Reason for application being invalid:

| <input checked="" type="checkbox"/> | Inadequate Plans | The following additional plans are required: <ul style="list-style-type: none">- Please submit an elevation drawing showing the front view of the proposed gate and fence.- The dimensions between the floorplan and elevation drawings do not match (e.g. the floorplan measures the length of the shed as 7.7m and the elevation as 8.4m) – Can you therefor please submit revised drawings to scale that measure the same on both drawings and include a scale bar (Or)

1:100 Floor Plan Proposed

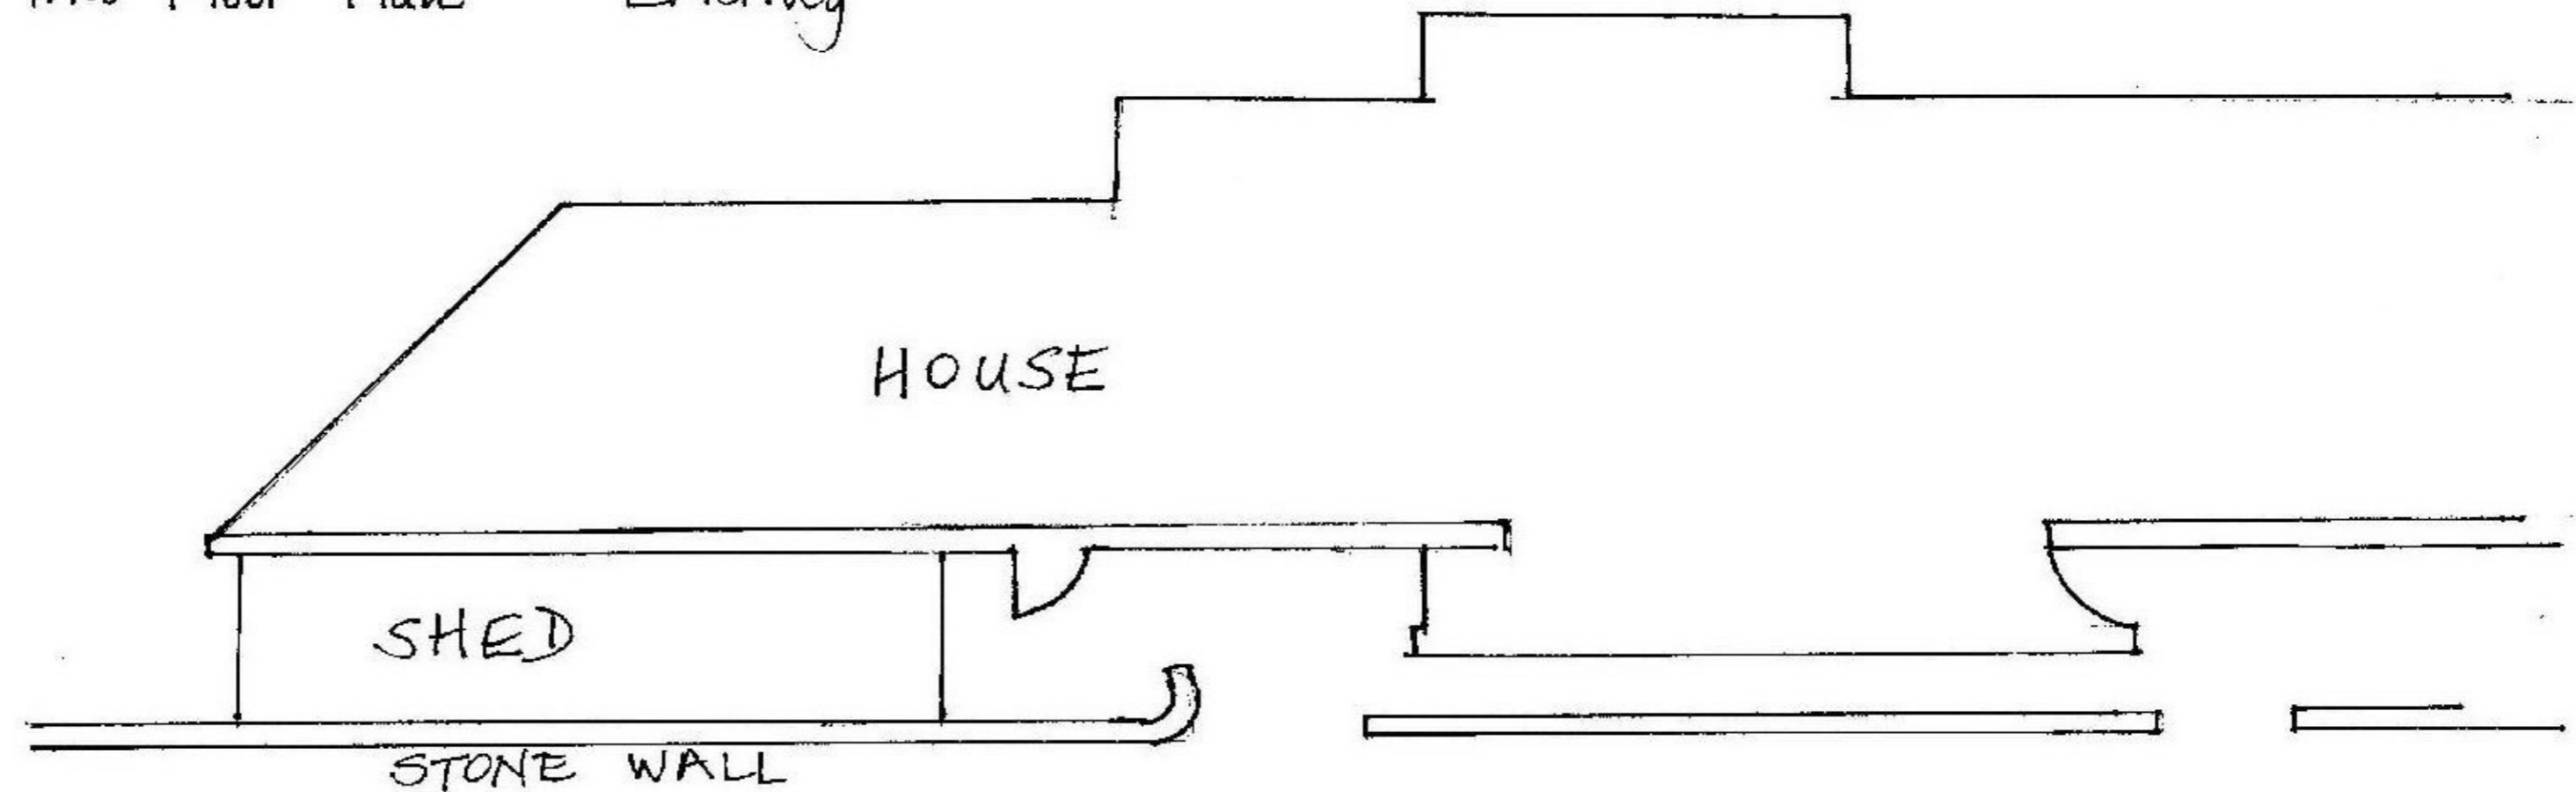
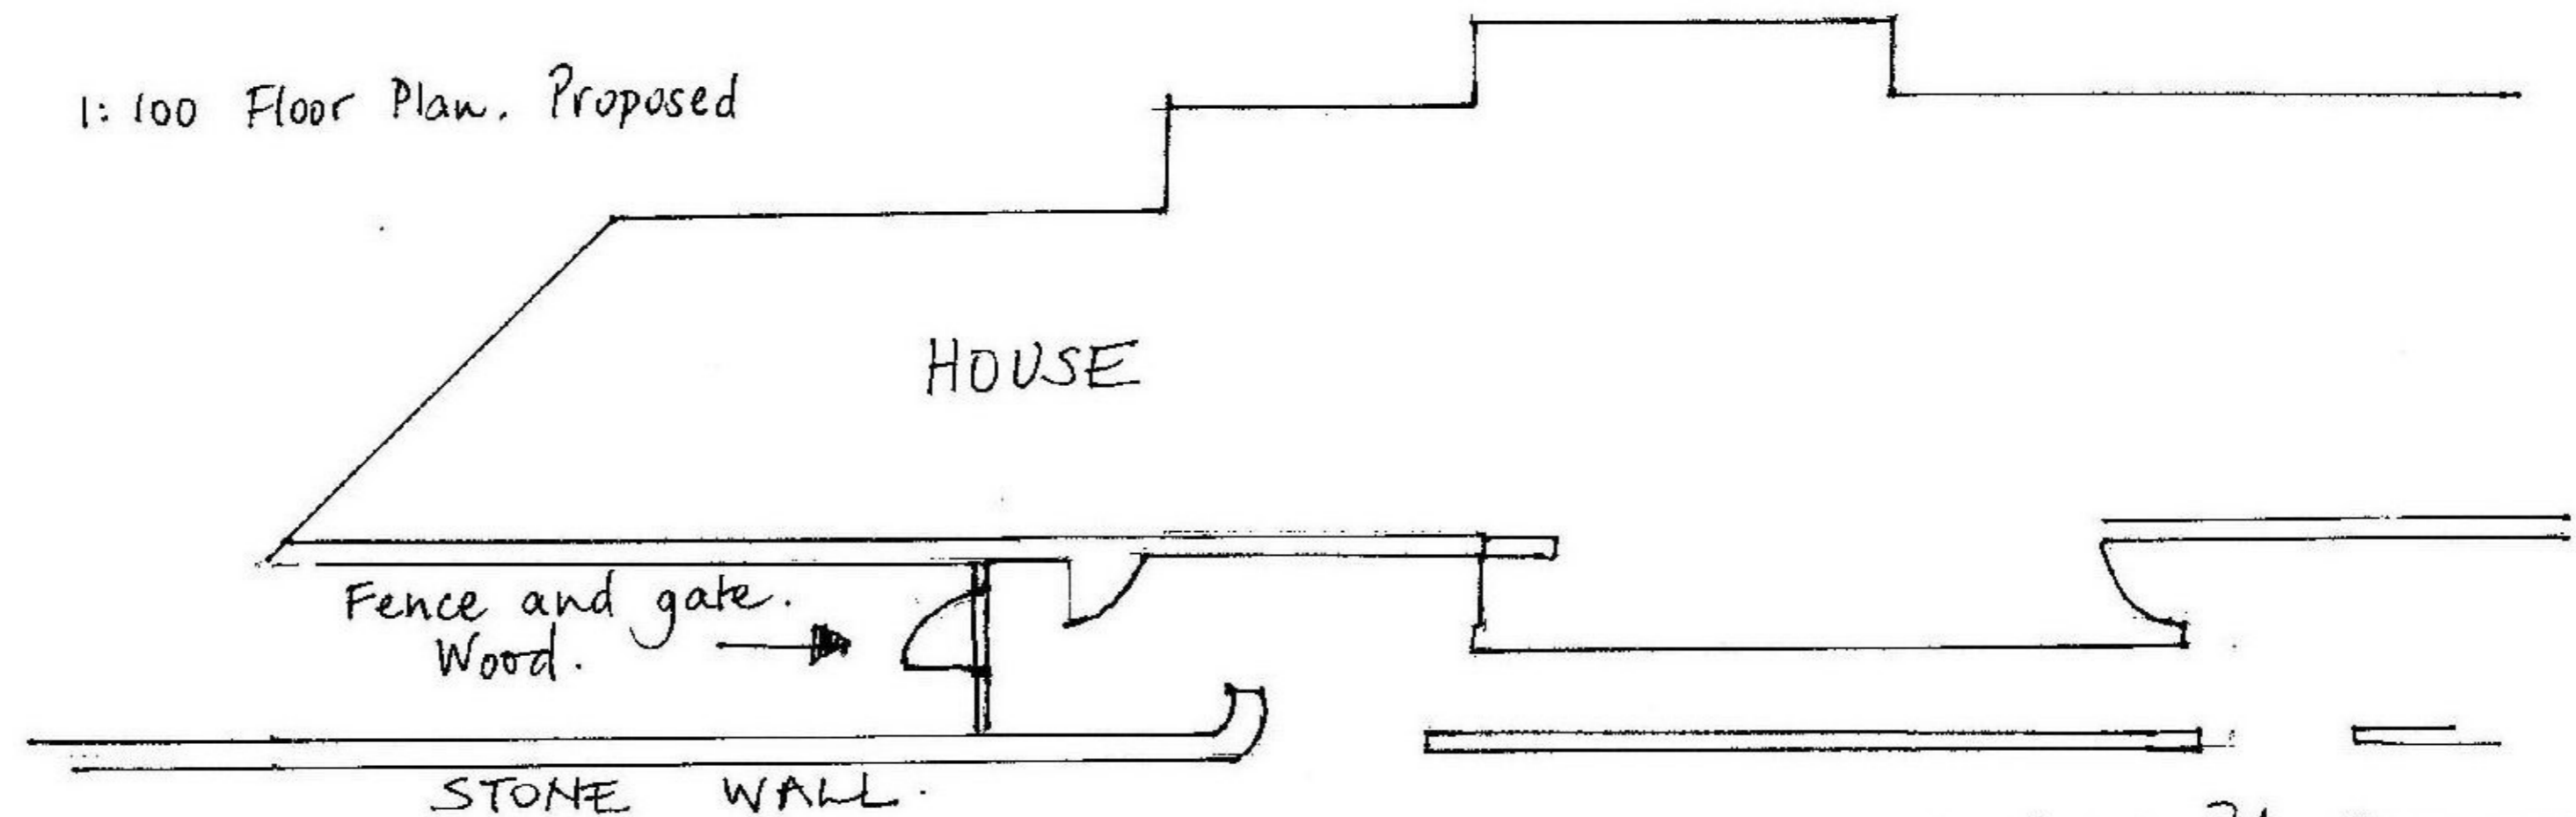
Alternatively, please submit a floorplan and elevation drawings that are fully annotated with dimensions |
